Recommendation Report for Planning Permission for Works or Extension to a Dwelling

REF NO: EP/78/20/HH

LOCATION: 4 Normandy Lane
East Preston
BN16 1LZ

PROPOSAL: Pitched roof rear extension and flat roof garage extension. (Enlargement of a previously approved scheme at 3.0m deep).

Project
Proposed details
March 2020

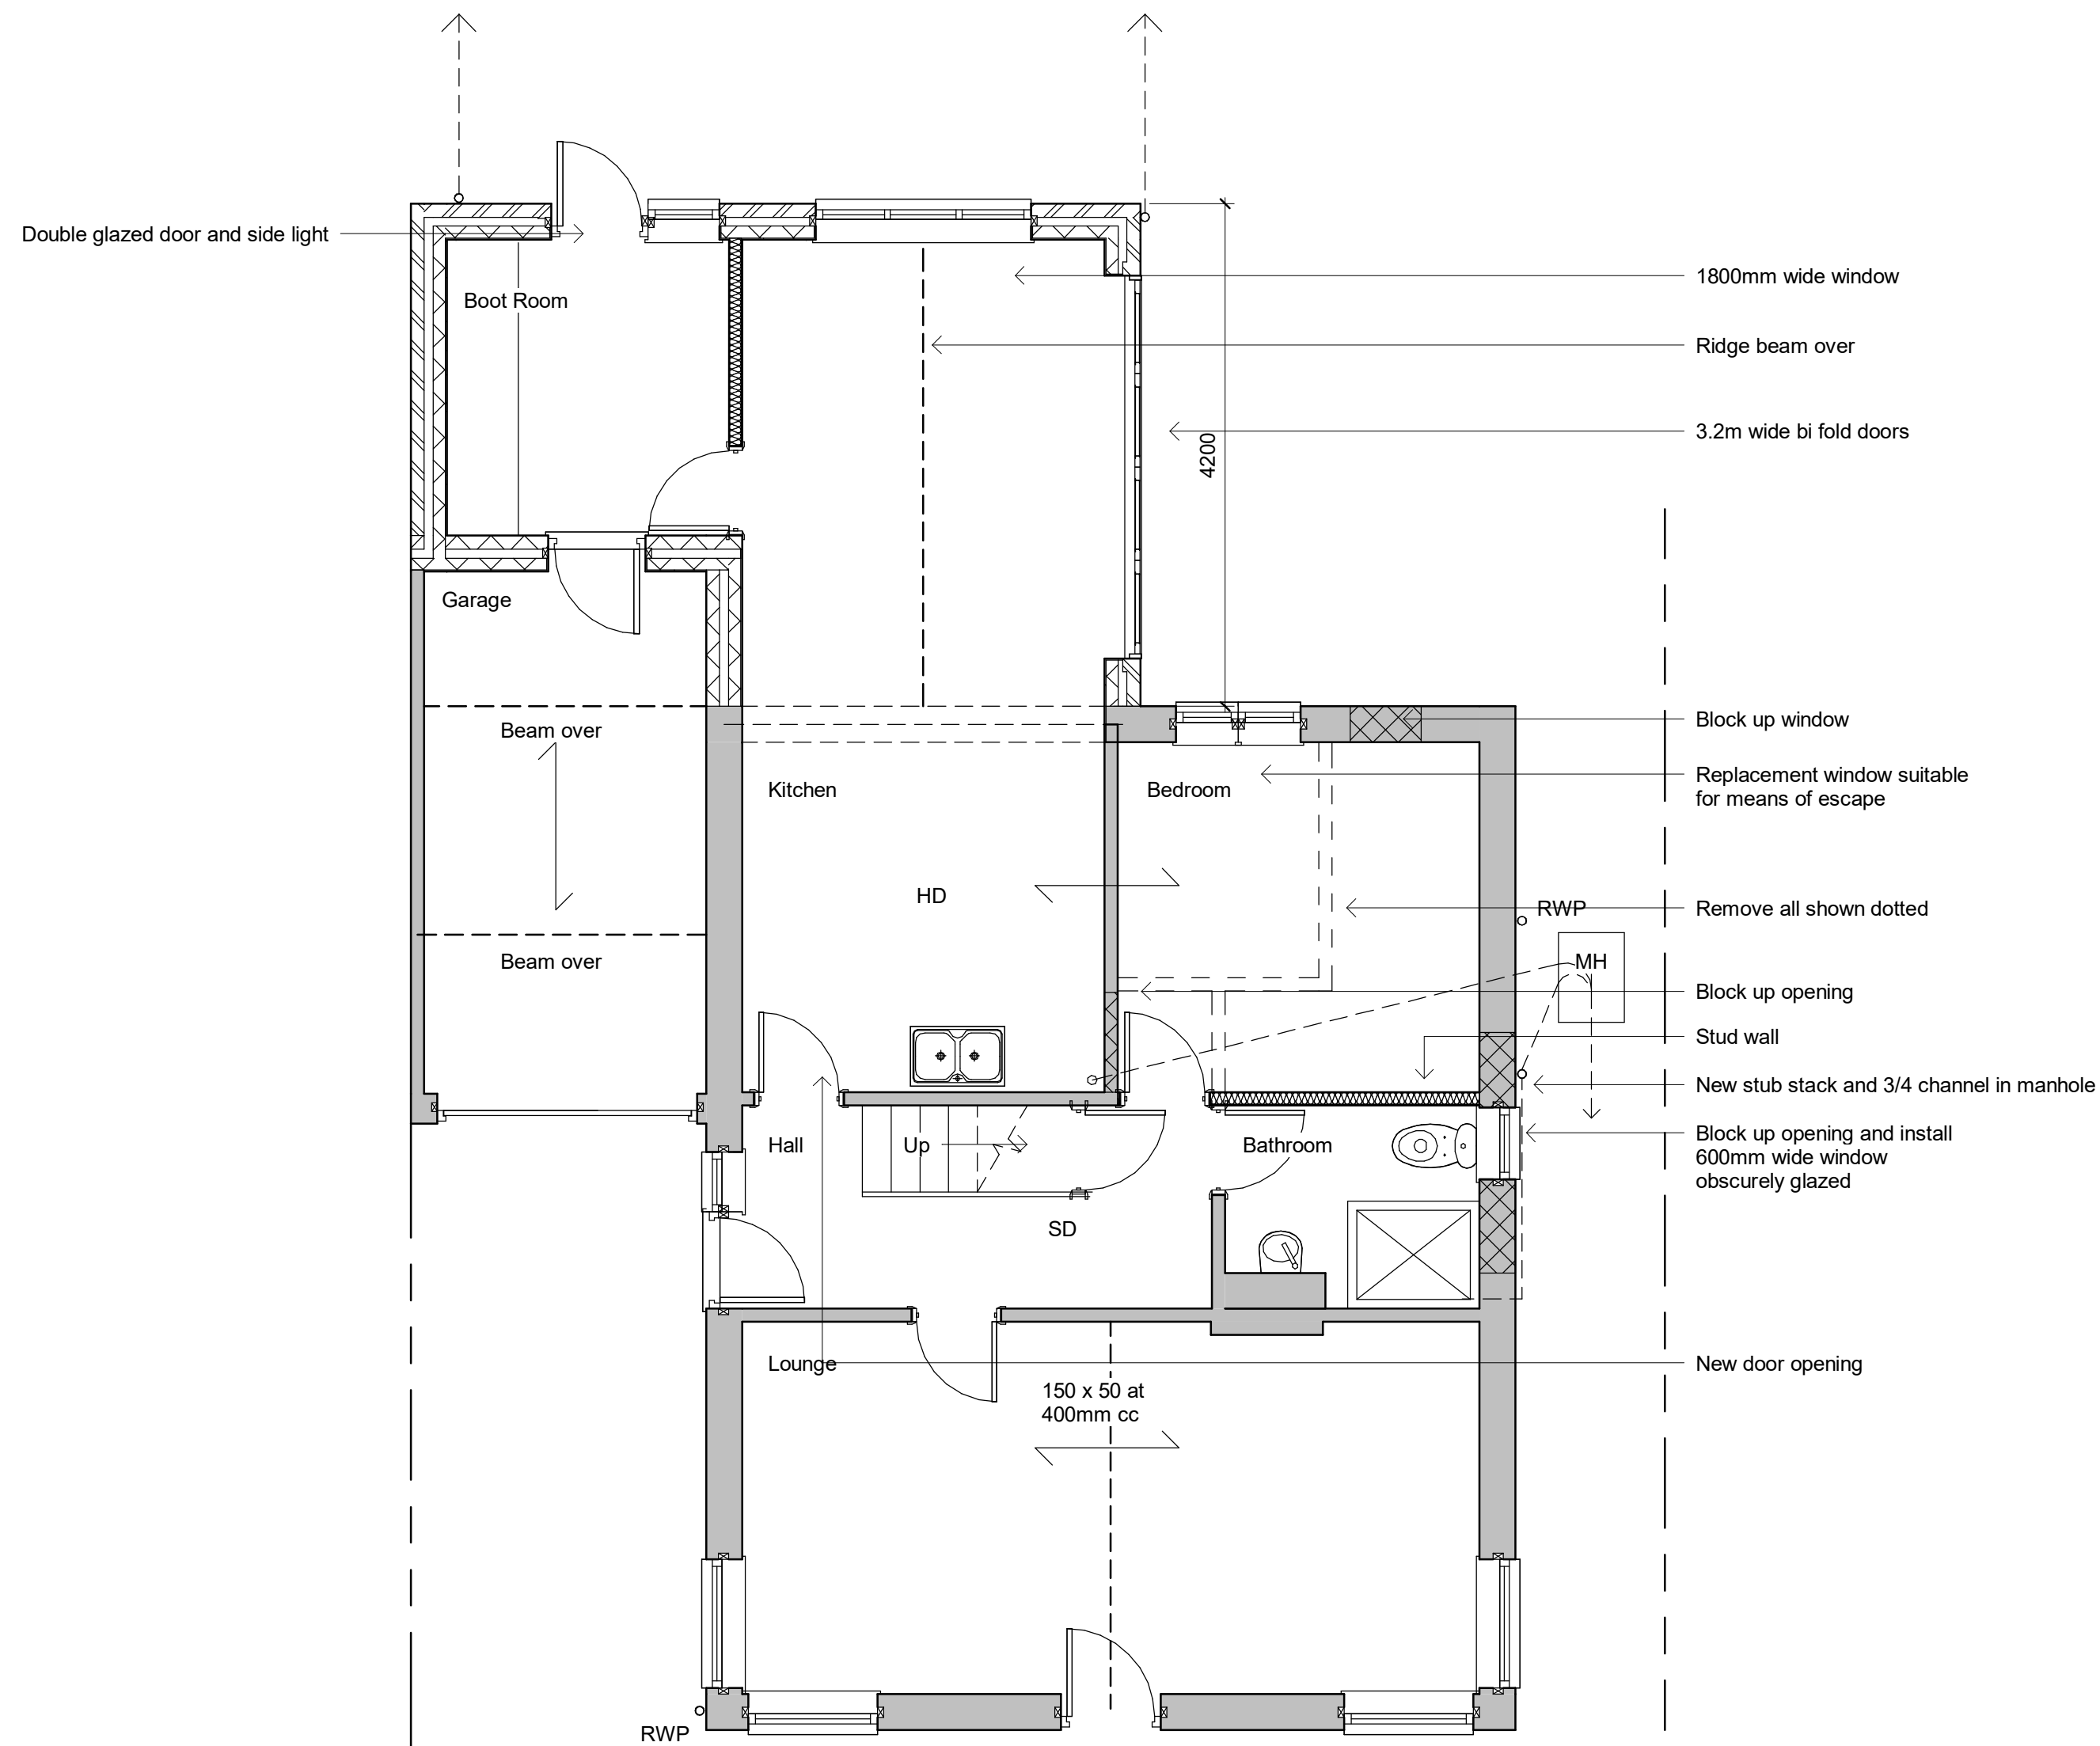
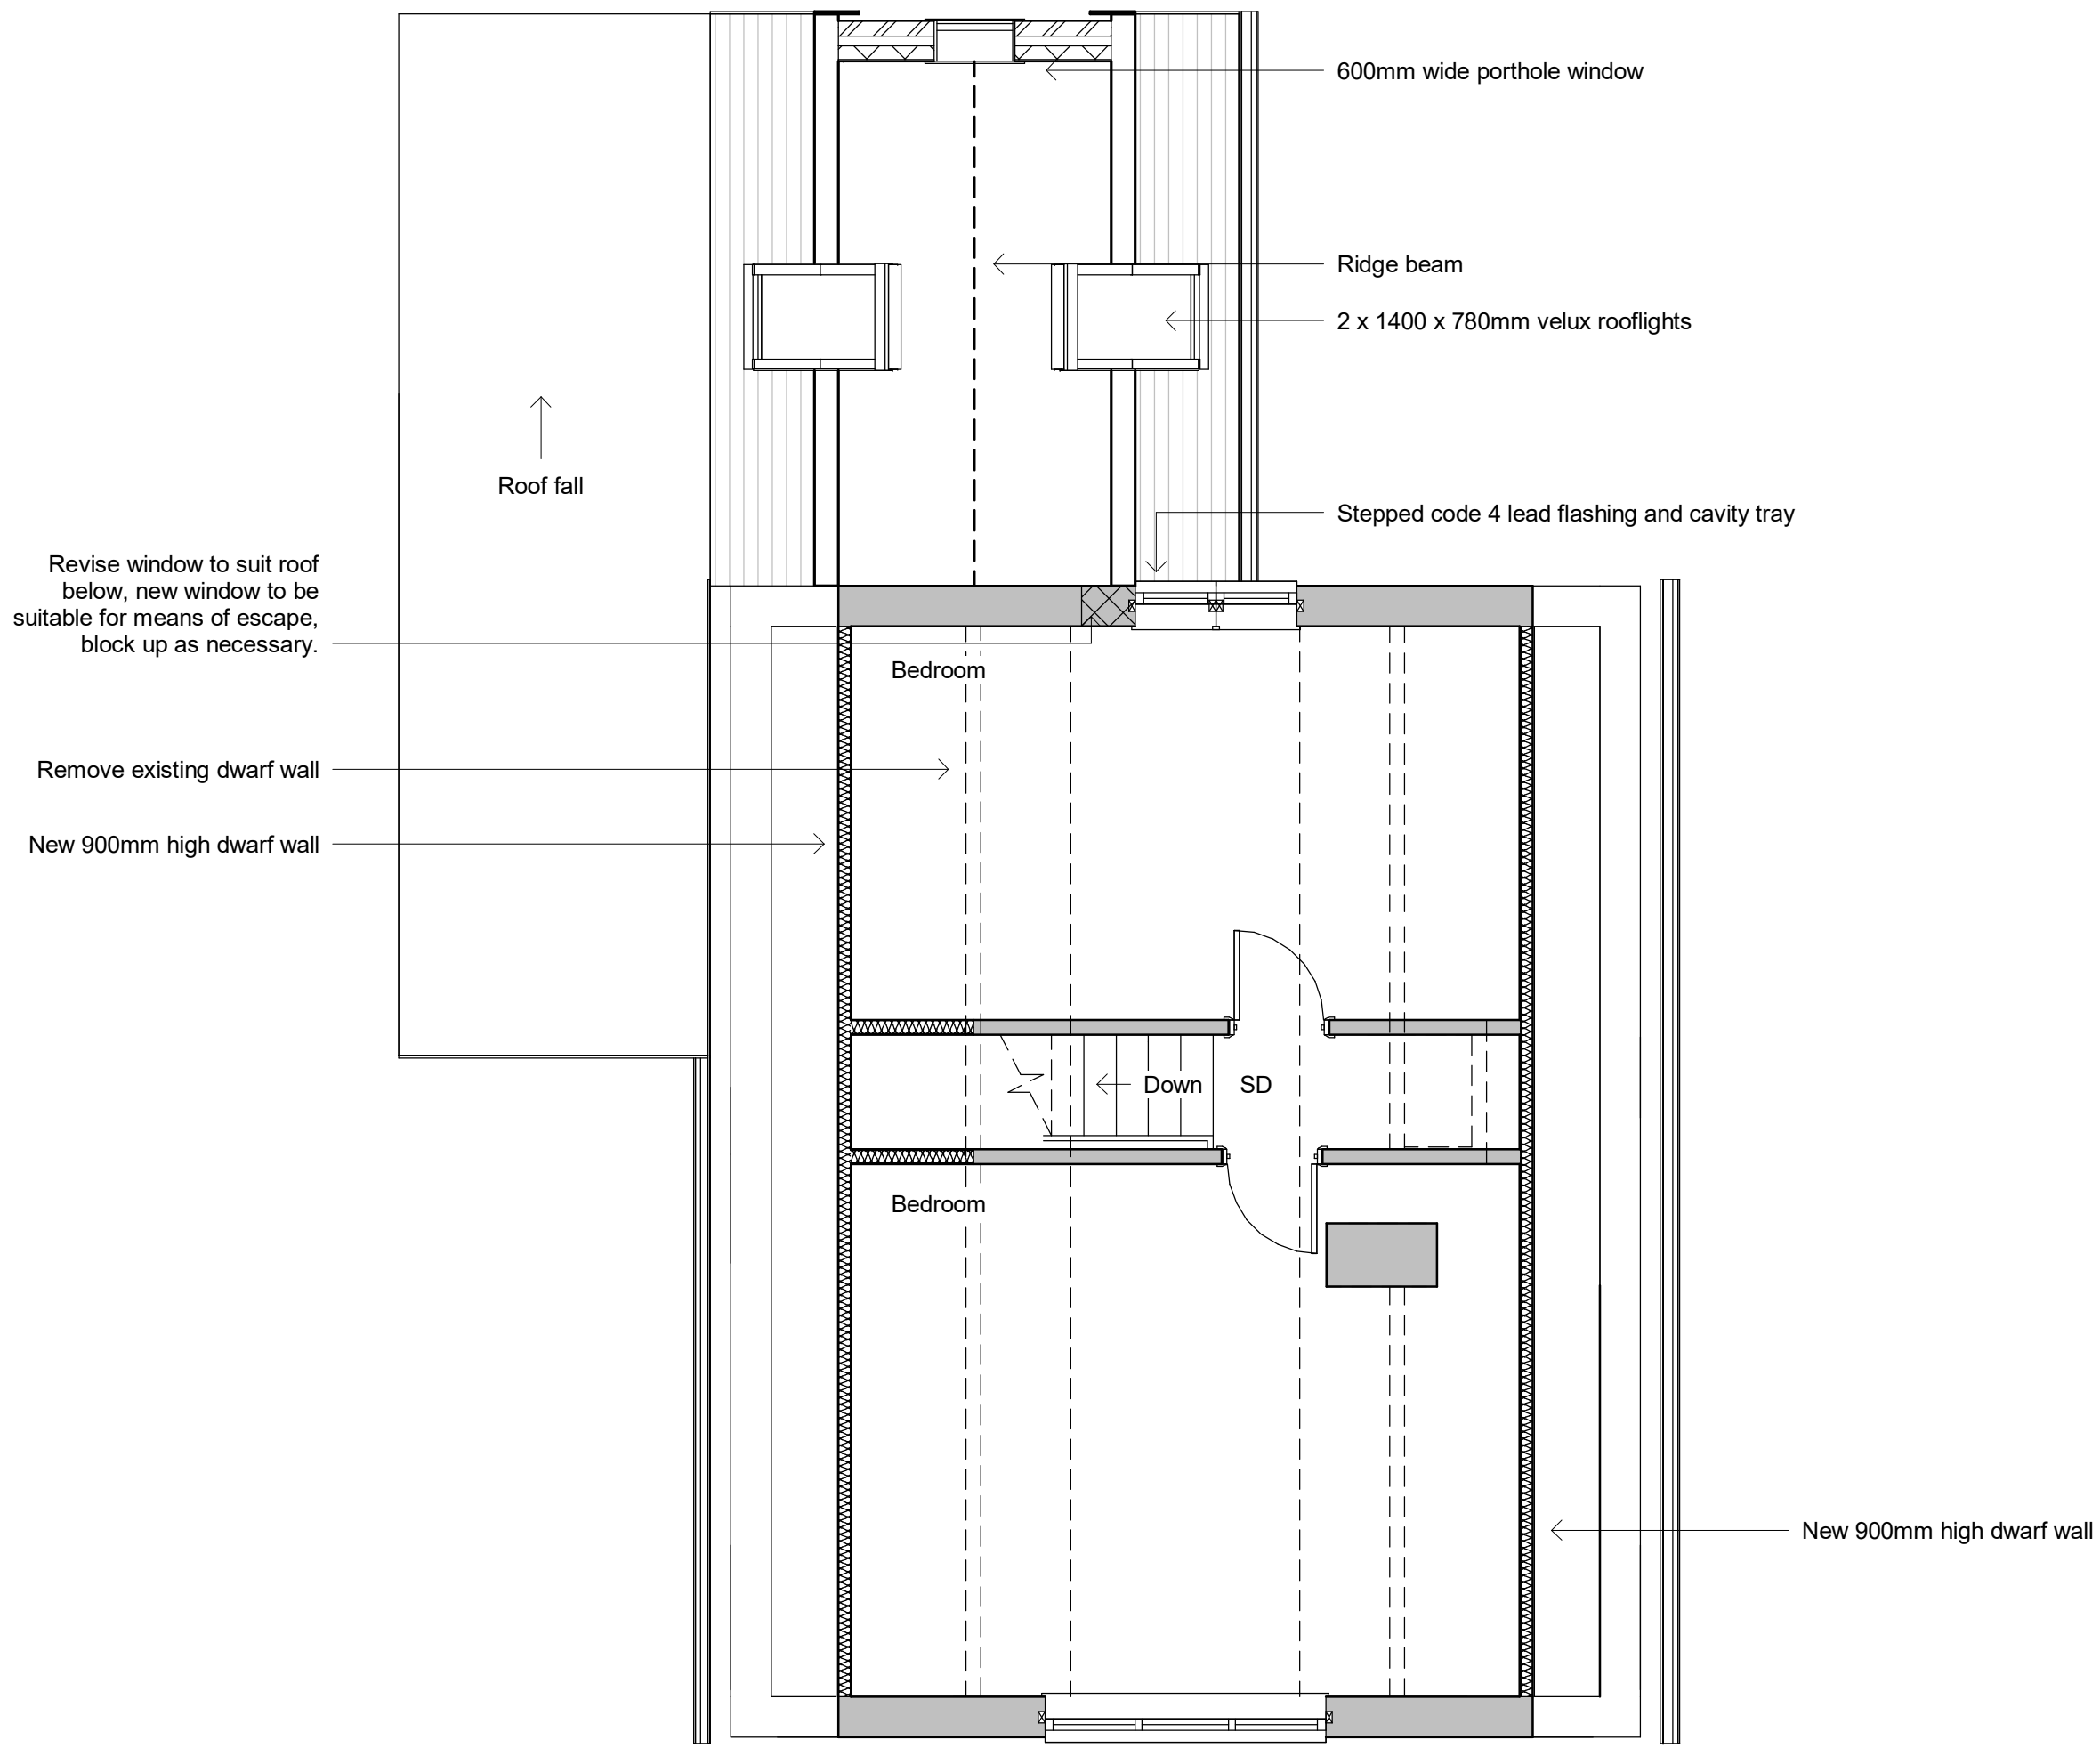
The development is similar to one already approved EP/31/20/HH with the only difference being that the extension projects to the rear 4.2 metres instead of 3 metres.

Due to its form and siting, there will be few available views of the proposed development from the public realm. The proposed pitched roof extension is considered to be a well integrated addition to the host dwelling, as a result of the proposed materials and roof slope angle of this extension. The proposed extension to the rear of the garage is considered to appear subservient to the host dwelling, as it matches the existing form of the garage current on the site.

The proposed development is not considered to result in any significantly harmful overshadowing or overbearing impact upon the occupiers of neighbouring dwellings, due to the modest form of the proposed development. The highest element of the proposal is approximately 4m from the Northern boundary of the application site, whilst it is noted that there may be some impact on the area directly adjacent to the site boundary, it is not considered to be so significant as to prescribe refusal of the application. The proposed garage extension is not considered to result in a loss of privacy to occupiers of neighbouring dwellings, due to its single storey nature. The proposed Velux windows in the pitched roof element of the proposed development are not considered to result in a loss of privacy, as they are at a high level.
